From: Laura Gibbons <Laura.Gibbons@arun.gov.uk>
Sent: 09 February 2021 11:50
To: Planning.Responses <Planning.Responses@arun.gov.uk>
Cc: Anita Gardner <Anita.Gardner@arun.gov.uk>
Subject: RE: Planning Consultation on: CM/2/21/DOC

Condition 11- surface water drainage design

Application No: CM/2/21/DOC

Site Address: Scyld Horsemere Green Lane Climping BN17 5QZ

DRAINAGE GA

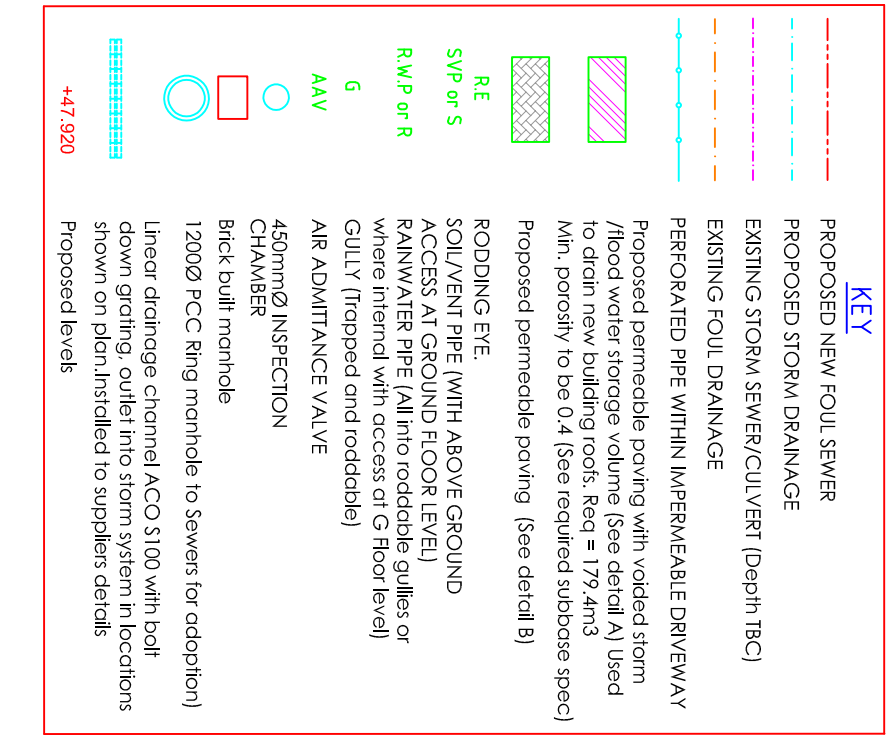
1. The calculations submitted use FSR rainfall and a cv of 0.75, please use Cv=1 or the latest FEH rainfall.
2. The invert level, and flow restriction of the hydrobrake are inconsistent between calculations and layouts. Please update to ensure consistency and include hydrobrake unit reference on surface water drainage layout and construction details.

3. Please ensure modelled slope of permeable paving is accurate.
4. Please detail finish and formation levels of permeable paving.
5. Please detail all pipe diameters and falls on plan.

6. A minimum of 300mm sump depth should be provided upstream of all connections into the permeable paving.
7. Where connections are being made to pipelines rather than direct to manholes – add note ‘all connections to be made using oblique 45 degree junctions’

8. Please indicate bed level of ditch upstream and downstream of proposed point of discharge, as well as at the point of discharge.

9. Please indicate invert level of outfall to ditch clearly. And update the position so this is accurate.
10. No connections are shown to/ from the permeable car park areas. Given the depth of groundwater these structures should be lined and have a positive means of drainage. Please ensure these areas are included within calculations and link to the road drainage.

1. Please supply further details of the proposed culvert, i.e. diameter, invert level, and construction details.
2. Please confirm proposed discharge rate, invert level, and existing bed level of watercourse, as per points above.
3. It is stated on the plans that the culverting has been agreed, we do not believe this to be the case. Please supply evidence that an application for land drainage consent has been made for both the proposed culverting and outfall headwall.

Date		By	Revision	OAD	Cmk'd	Ref
Dec 2020	Scale AS SHOWN					
CkWV	Cmk'd EG OAD EG					
	Drg No.					
	424955-11P1

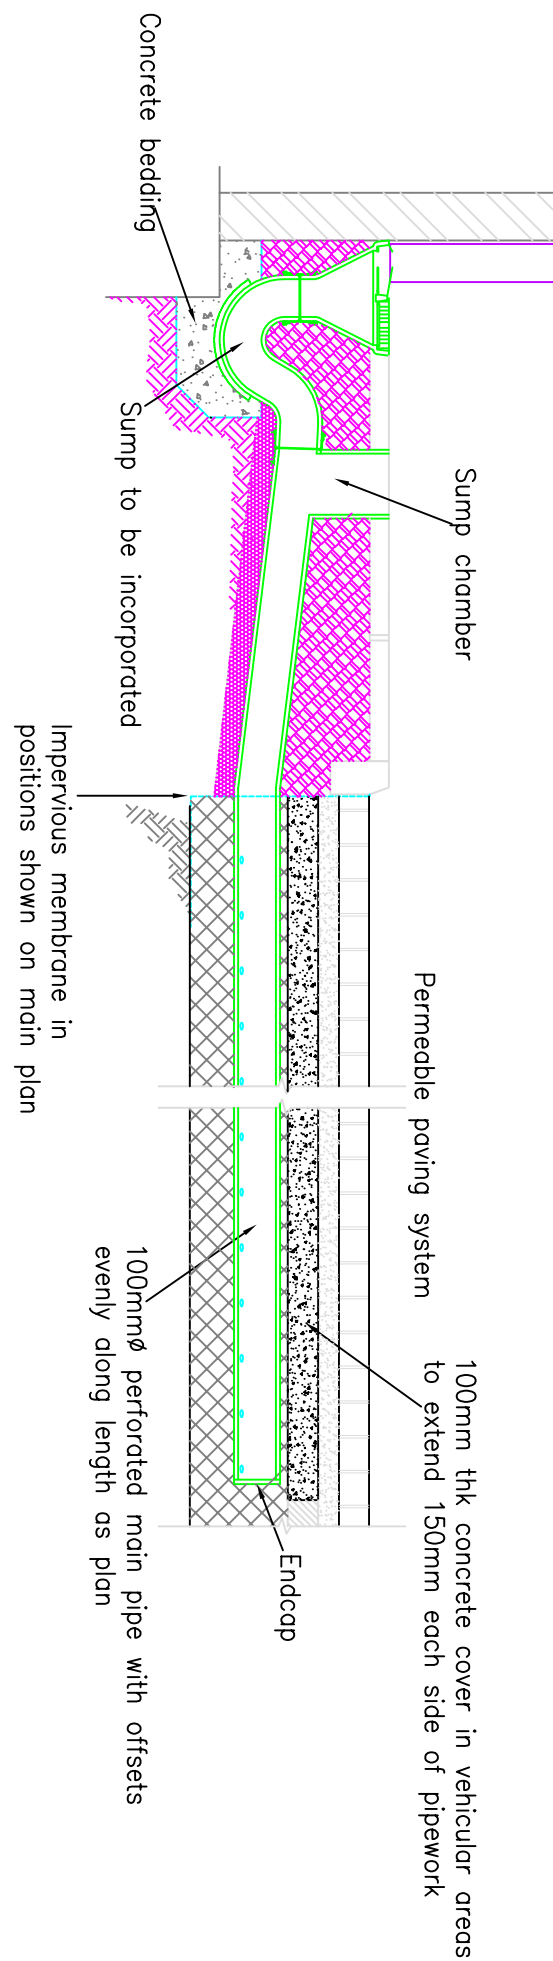
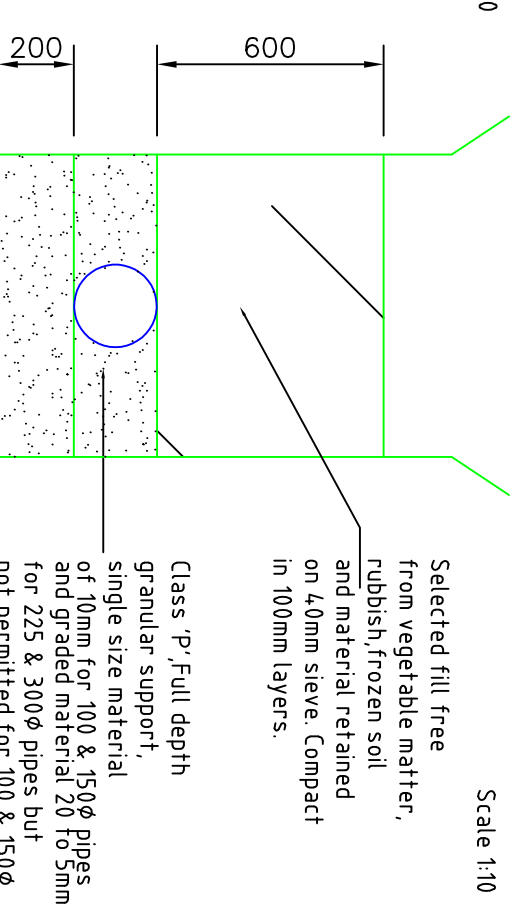
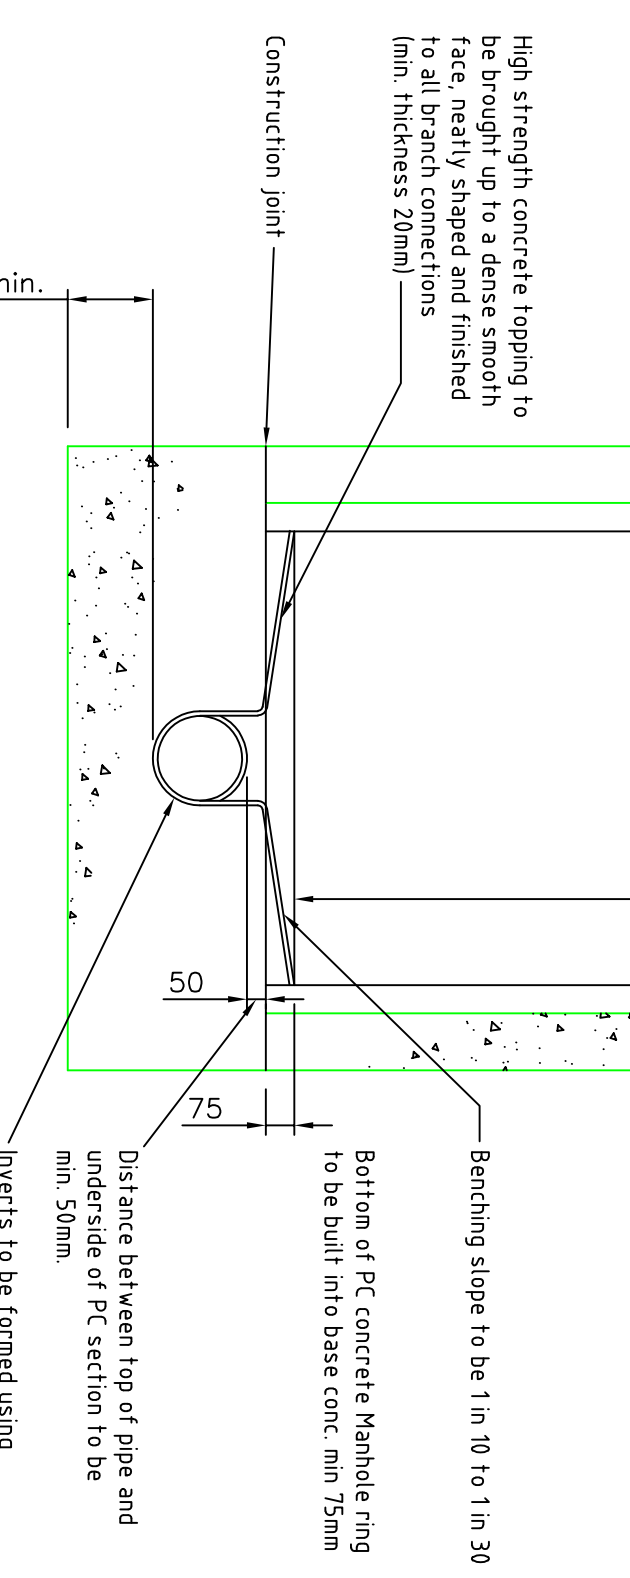
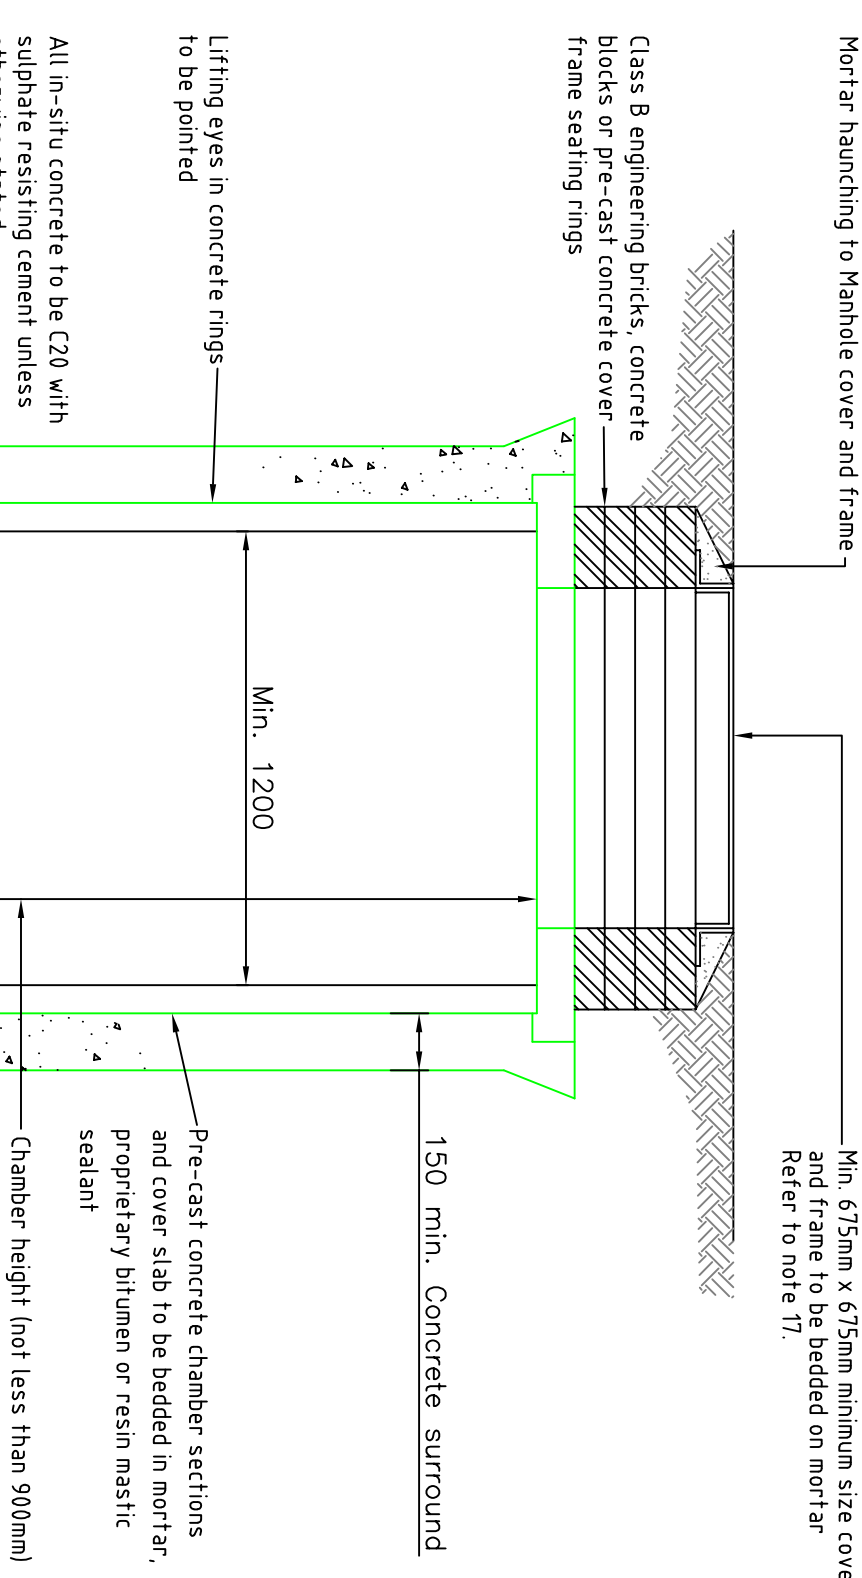
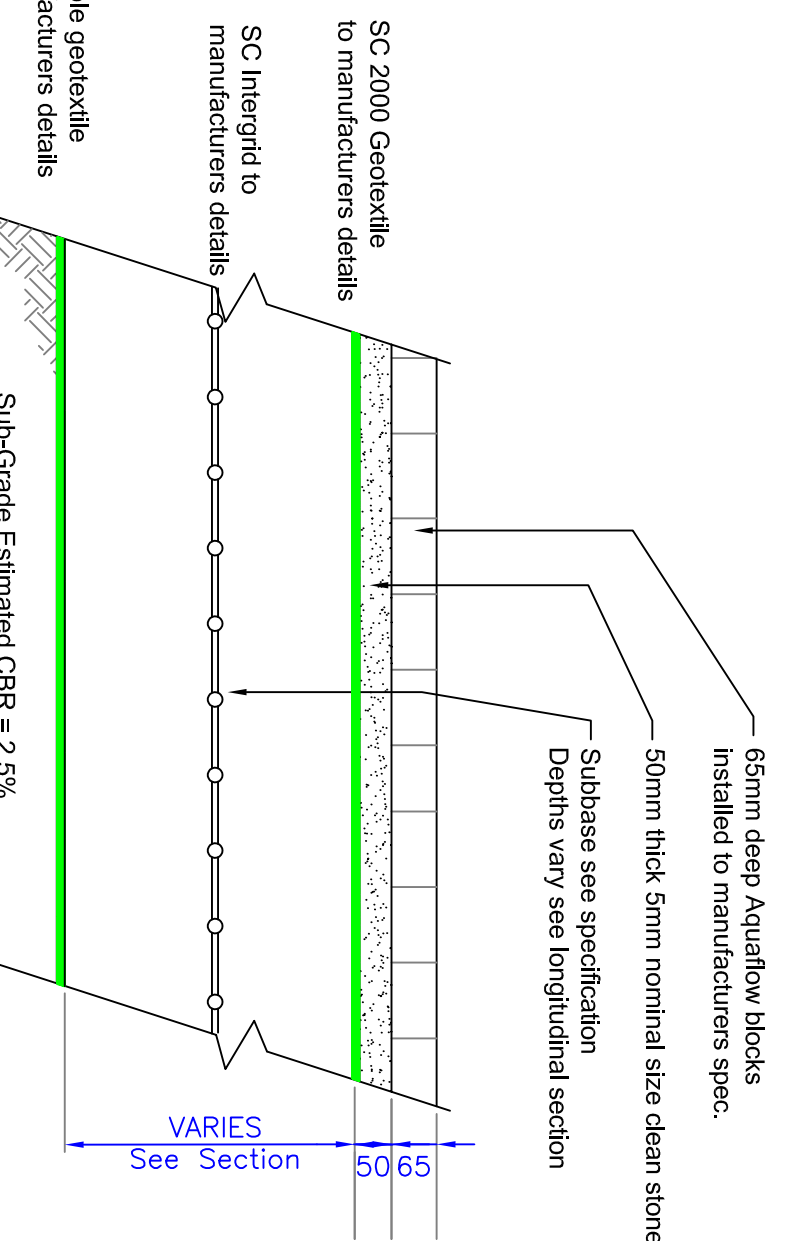
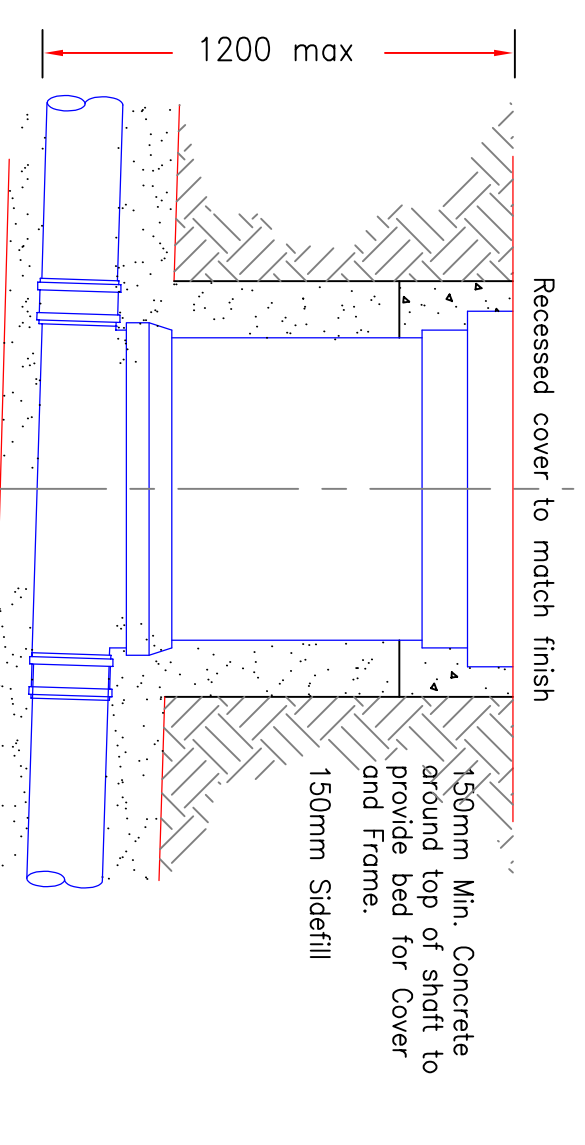
11. Please provide construction detail drawings of : hydrobrake (site specific); drainage channels, catchpits, and proposed headwall.
12. The permeable paving details must show an impermeable membrane around the side and base.

13. The permeable paving details must indicate minimum depth of sub-base and sub-base material.
14. I note that it is proposed to have a 100mm thick concrete cover slab over the top of the perforated main pipe, with 150mm each side of pipe work. This would have to be constructed very carefully so as not to cause concrete ingress into the perforated pipe, and it will also result in a strip of road being impermeable. Has the use of diffuser units been considered instead with a small fall in formation over the site? The outlet diffuser unit would have to be at the base of the sub-base. As should the pipe at the downstream end if this is to remain.
